Application No: MP07_0158 MOD 3

Exhibition of Modification Request for the University of Sydney Abercrombie Precinct Redevelopment

Date: 11 November 2013

Name: Claudia Scheibe

Ground Floor Plan
1:200@A1
11.10.13
4001_DA02-D

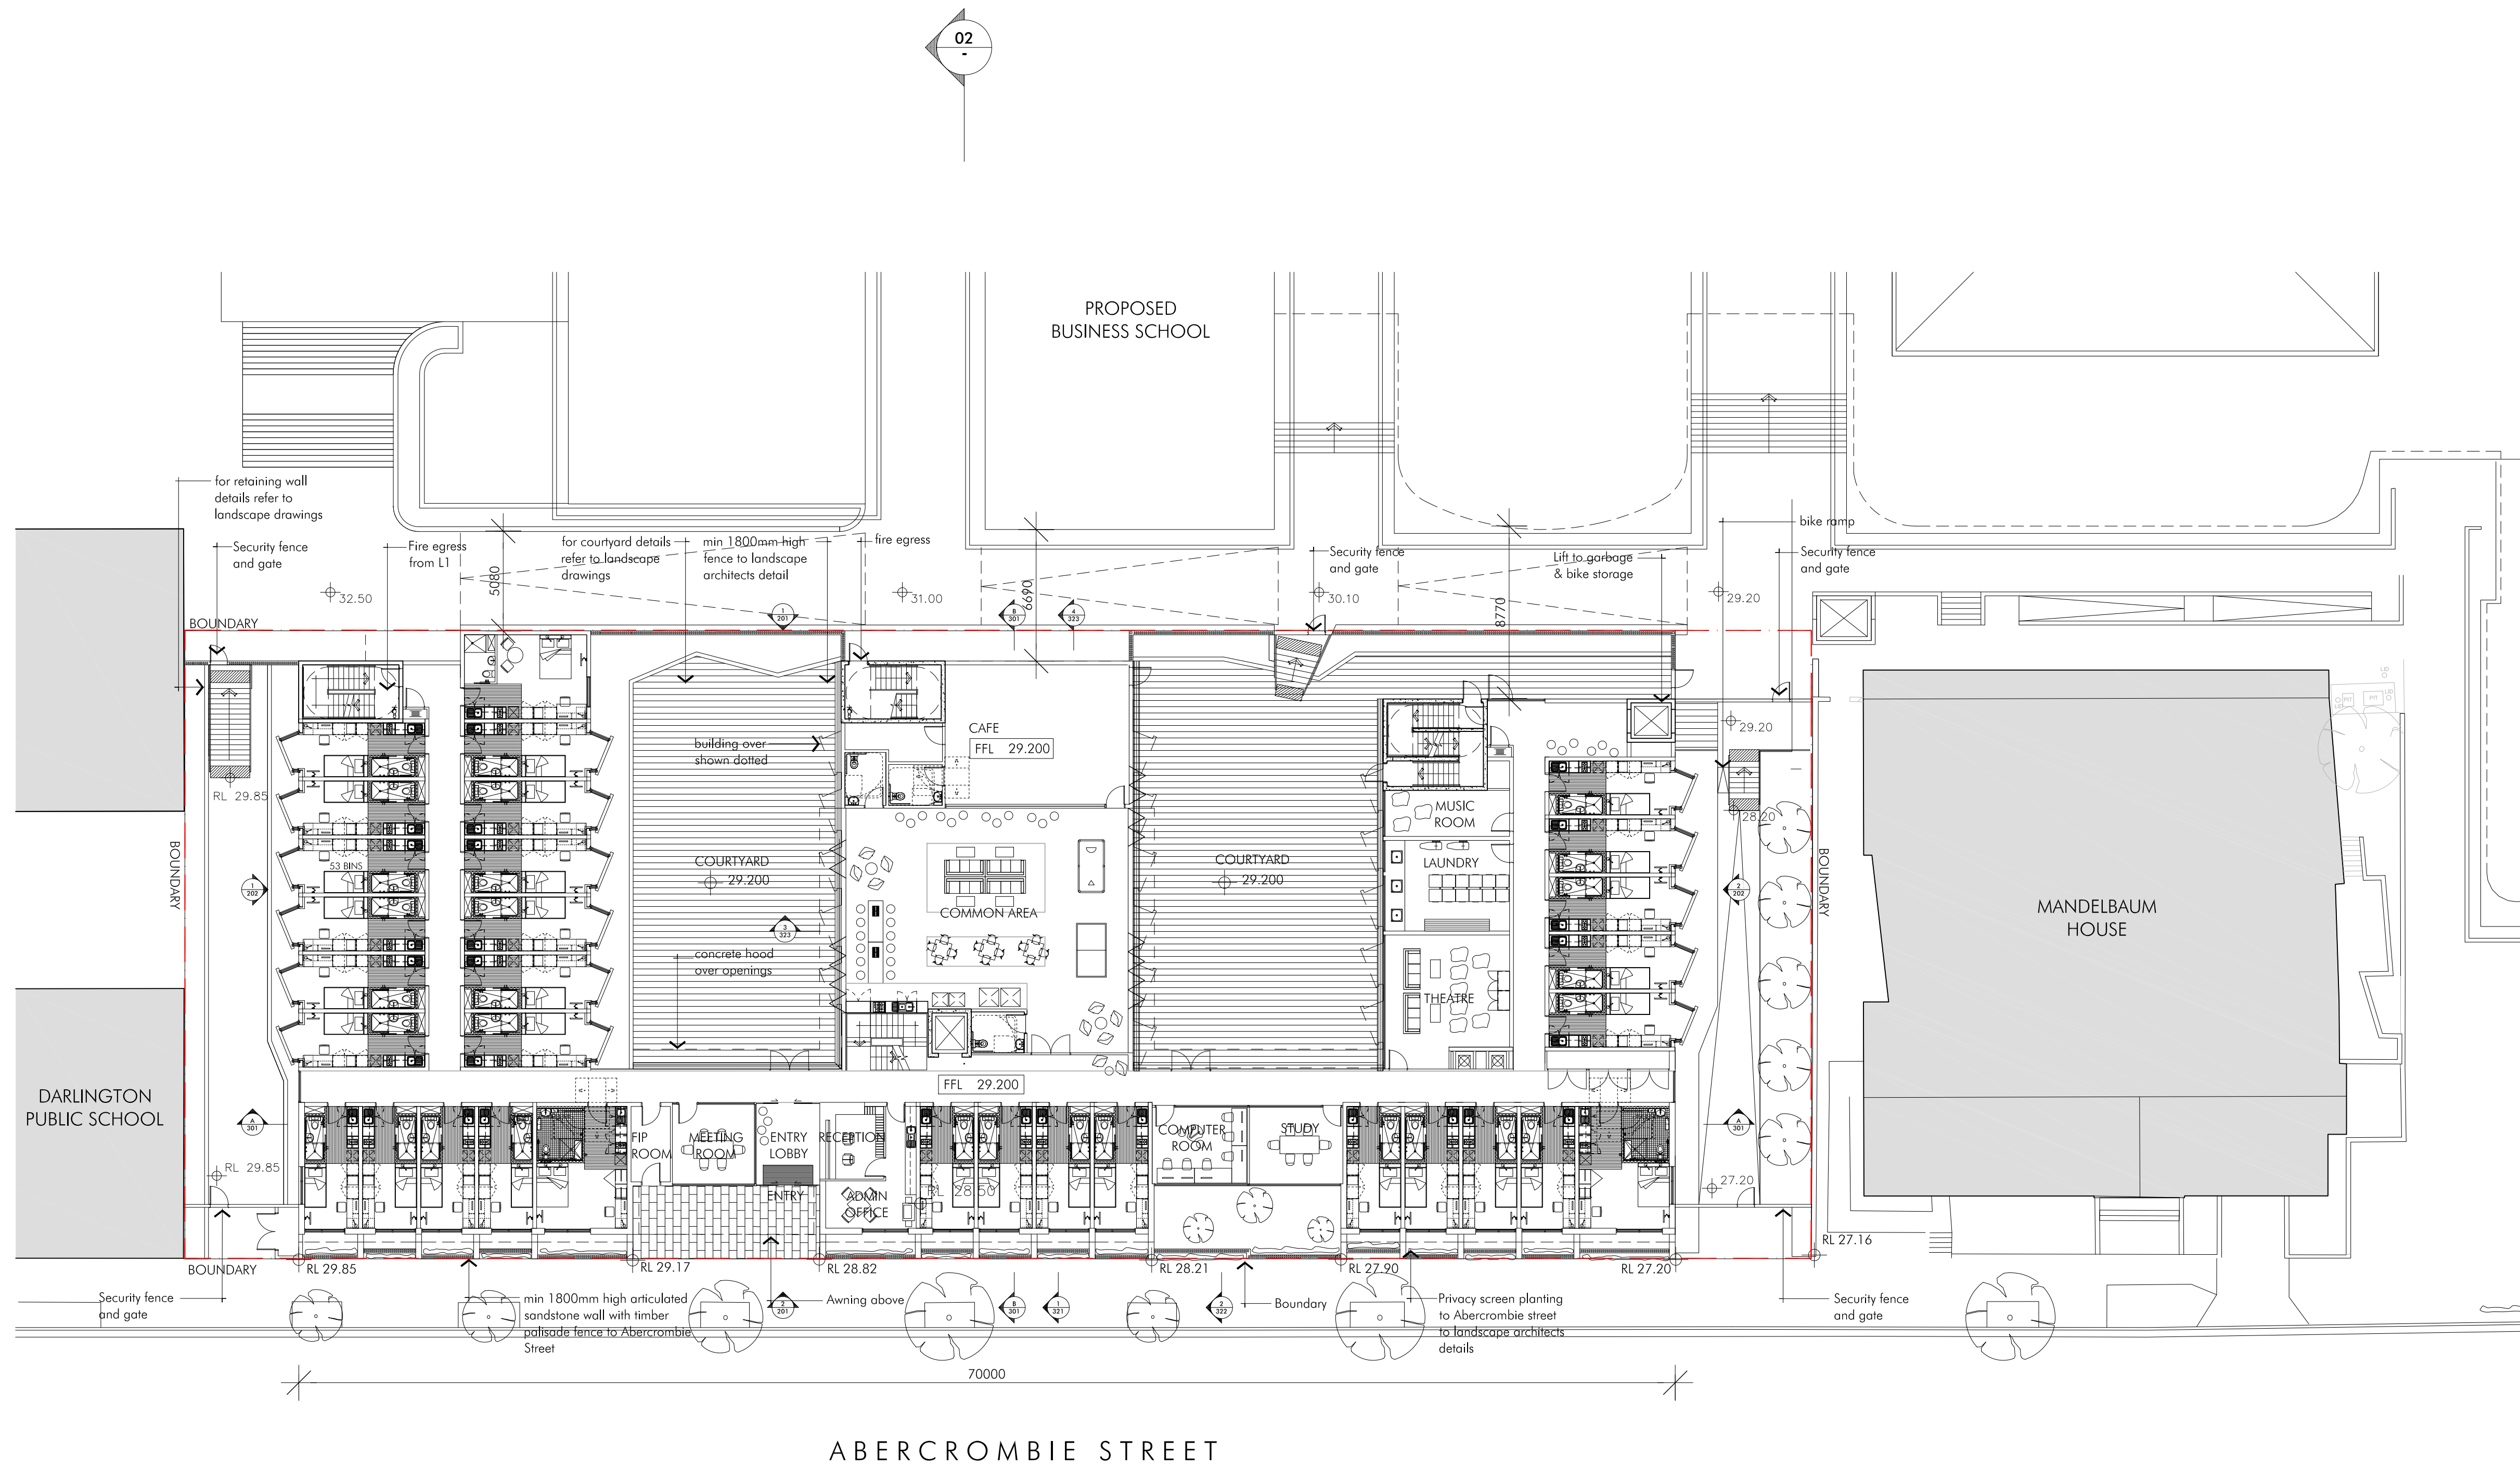
The latest plans for the Student Accommodation, whilst showing the front of the building abutting the boundary on Abercrombie Street, also show an increase in floor area at the back towards the Business School.

The whole building should be moved back to align with Mandelbaum House as it was originally planned and presented to the residents - see above pictures. There should be no increase in floor area at the back and the number of students living in the facility should be restricted to the originally approved 188 or to an even lesser number. The number of students should not be increased to 200 as is now proposed.

Access pathways are proposed for either side of the new Student Accommodation running from Abercrombie Street into the APD at the back of the Student Accommodation.

The areas at either side of the proposed Student Accommodation should be kept as green areas. The provision of heavily landscaped buffers at each end of the Student Accommodation will discourage students and other groups from congregating at all hours bringing noise and disruption to residents living nearby as well as those living within.

Students living here will be able to access the University through the back of the building, therefore these access paths are not warranted.

The plans show a music room facing into Abercrombie Street. This room and any others that would have loud noise and are places where students will gather in numbers must be sound proofed protect the amenity of residents.

02 ELEVATION SOUTH (ABERCROMBIE STREET)
SCALE 1:200

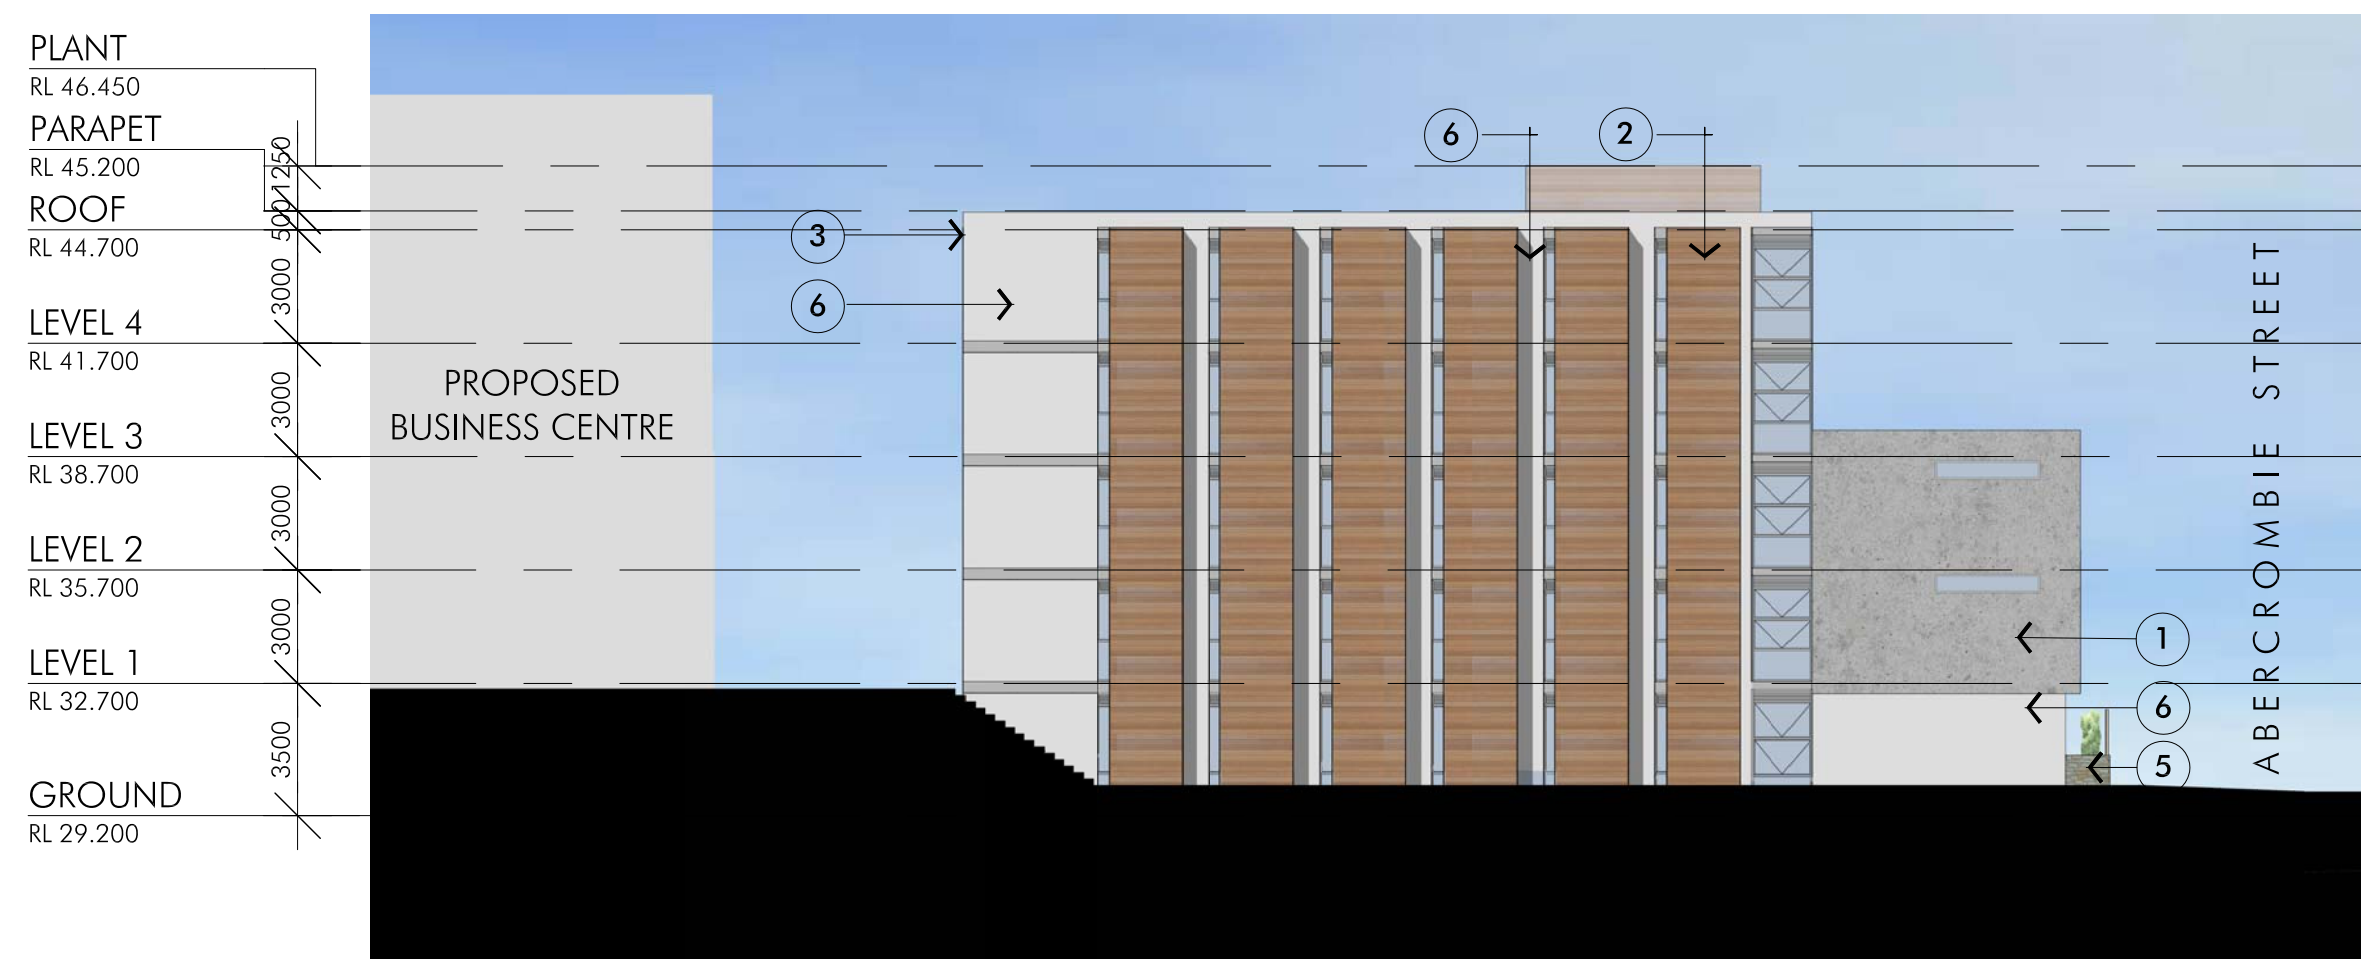
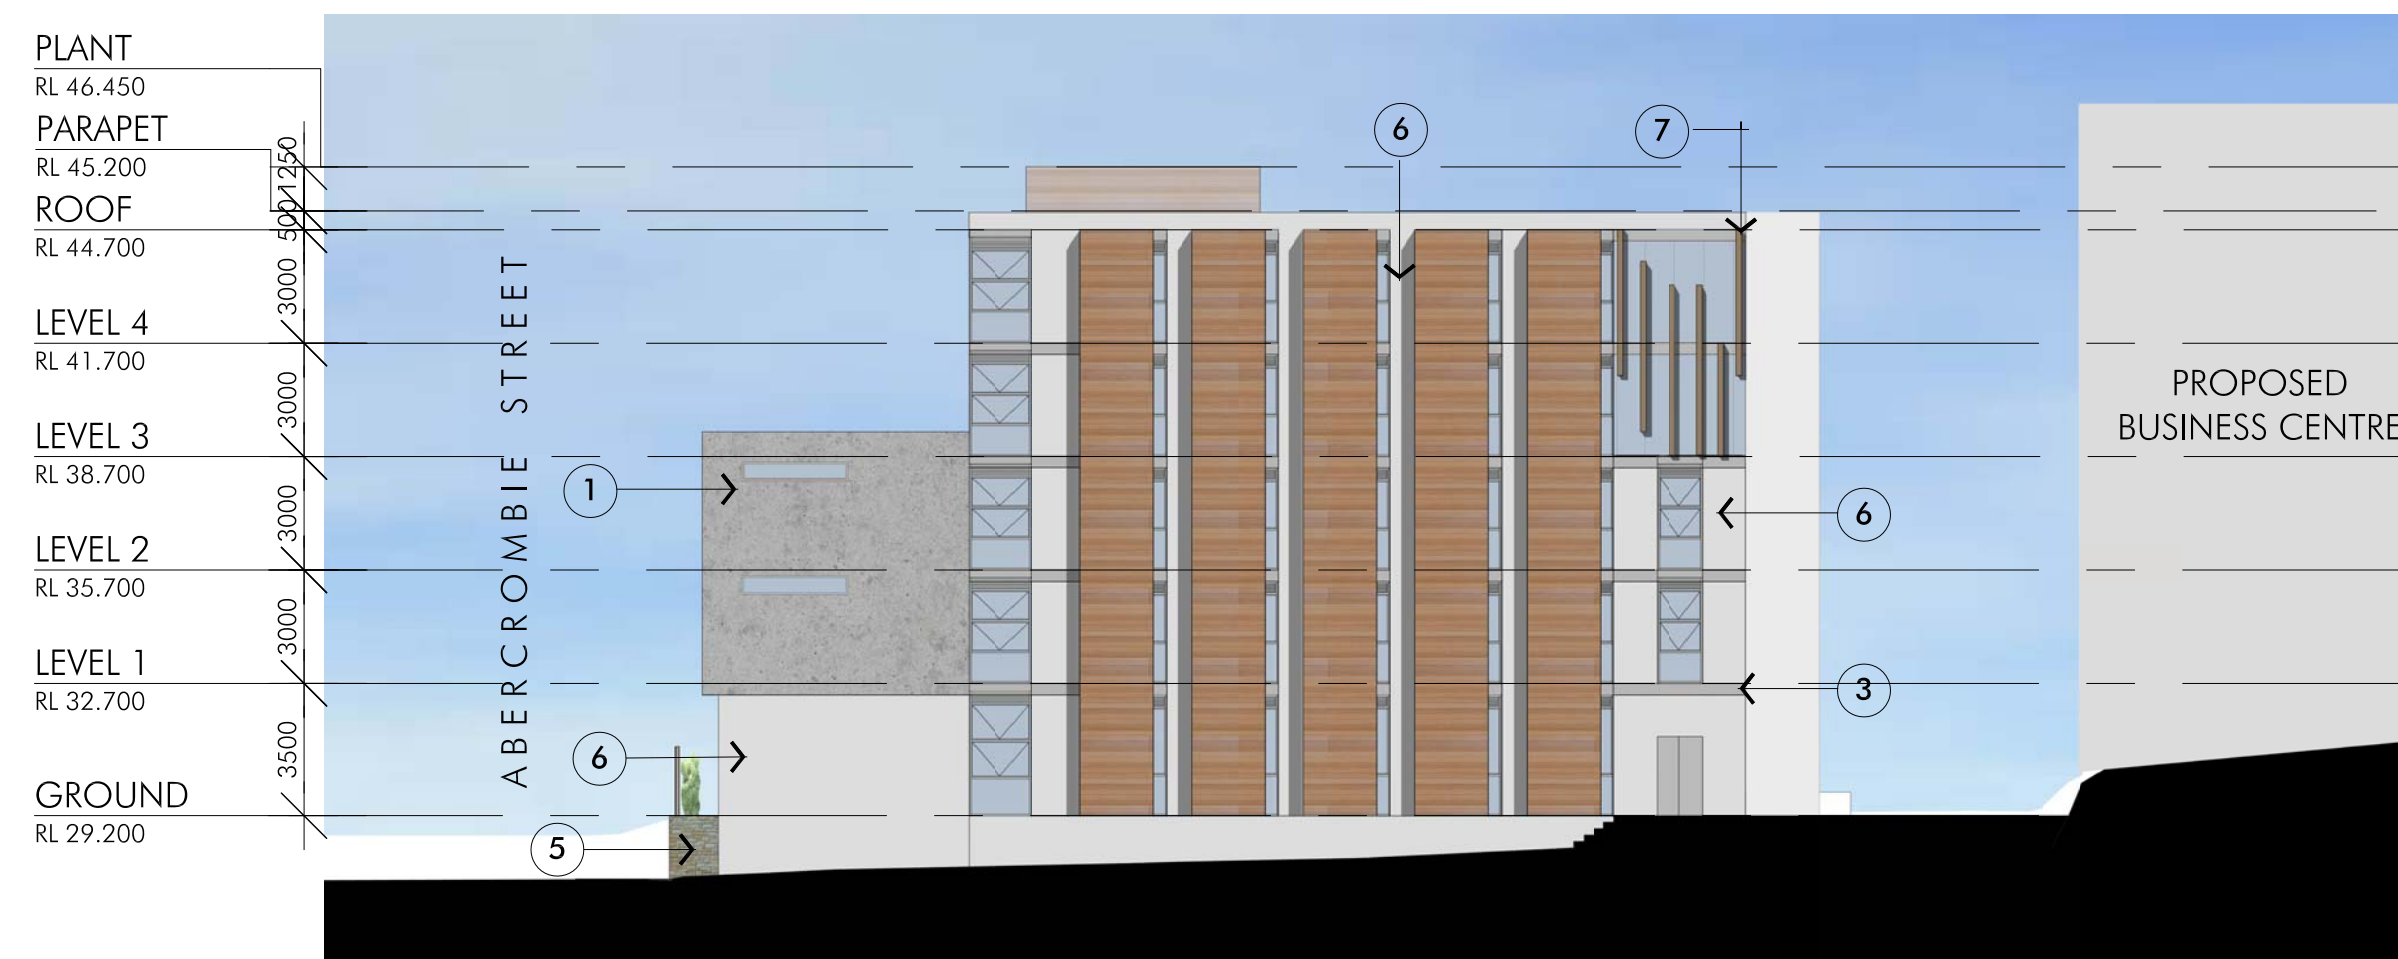
This picture is grossly inaccurate in its depiction of the perspective and proportions:

- The people walking along the street in the picture would only just fit into the rooms on the ground floor. It appears as though the building would be built below ground level. However, this is not the case.
- The Darlington Public School building in the left of this picture is a 2 storey building yet appears to be the same height as the 5 storey Student Accommodation next door.
- The University's own picture below gives a truer idea of the way in which the Student Accommodation would be much higher than the Darlington Public School building to the left and also Mandelbaum House to the right.

- The University's own elevation below clearly shows that Darlington Public School, outlined in red on the left of the picture, is a 2 storey building which sits well below the 5 storey Student Accommodation.
- The red line at the top of Mandelbaum House on the right of the Student Accommodation is actually the height of its pitched roof.

Many objections made to the original plans for the APD Business School and Student Accommodation buildings were on the basis of their height, bulk and scale, especially as they are proposed to stand much higher than Mandelbaum House to the east and Darlington Public School to the west, dwarfing both of them.

The scale of the proposed Student Housing building along Abercrombie Street is up to five storeys, which is out of character with the prevailing height and scale of the 2-3 storey Victorian terraces on the southern side of Abercrombie Street and a number of other traditional buildings mainly located at the intersection between Abercrombie Street and Codrington Street.

- The building should be reduced in height and scale so that it is consistent in height with Mandelbaum House and conforms to the established 2-3 storey characteristic height of buildings along Abercrombie Street.
